## PLANNING CONSULTATION RESPONSE

<b>Application No</b>	2026/0194
<b>Proposal</b>	Removal of associated BT payphones and the installation of 1no. BT Street Hub with 2no. digital LCD display screens, one on each side of the unit. (Advertisement Consent)
<b>Address</b>	Pavement o/s 48 Cheapside, Barnsley, S70 1RU
<b>Date of Consultation Reply</b>	31/03/26
<b>Consultee</b>	Highways DC

Drawing Title
EXISTING AND PROPOSED ELEVATIONS

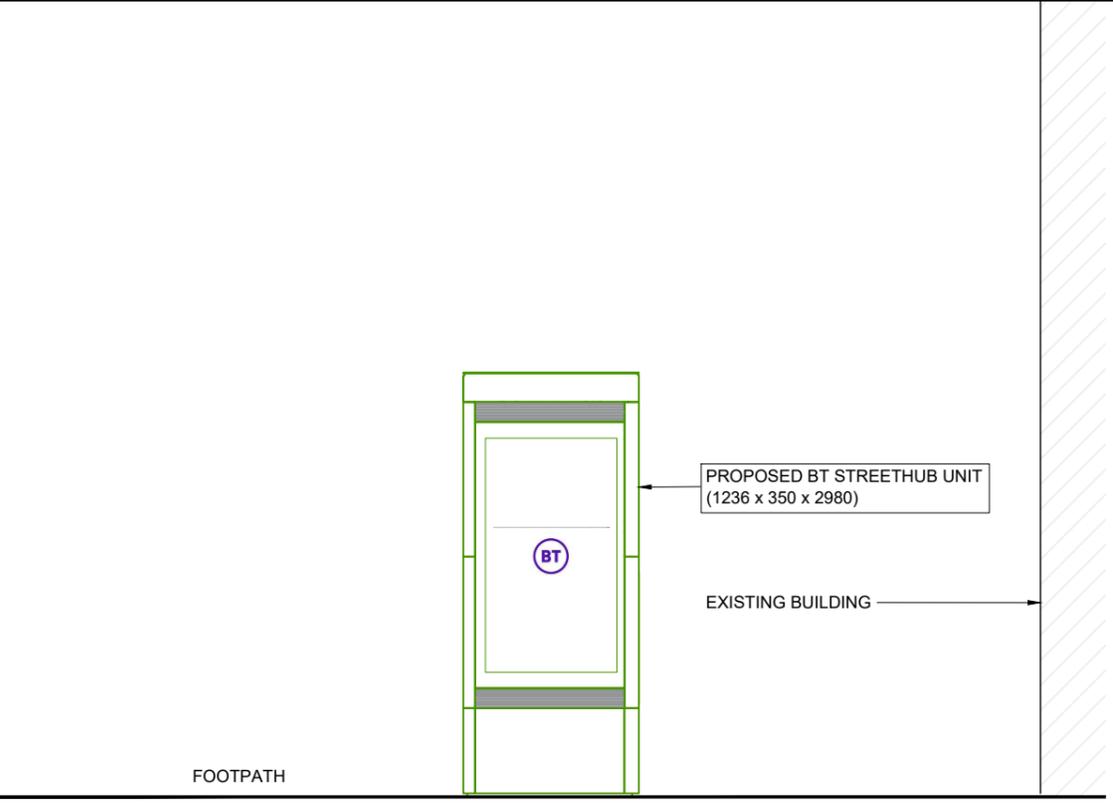
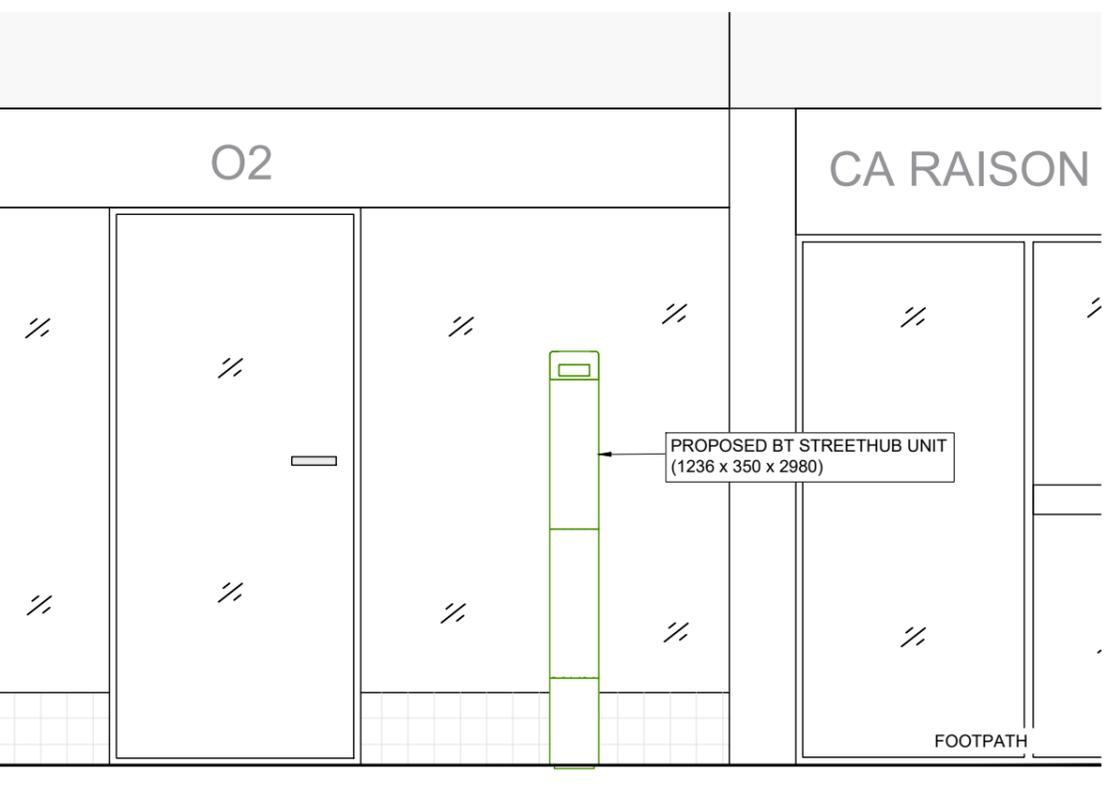
This proposal involves the removal of an existing BT payphone box and the installation of a new BT Street Hub. The Hub design is slimmer and takes a more compact profile than the existing BT payphone boxes being replaced; as such, whilst the HDC officers would wish to see street clutter reduced, there would be no justification for objecting to the scheme on these grounds as there is no overall increase in street furniture.

The Street Hub is positioned in a pedestrianised precinct on a wide section of pavement without impeding pedestrian or delivery vehicle movements with ample footway width being retained.
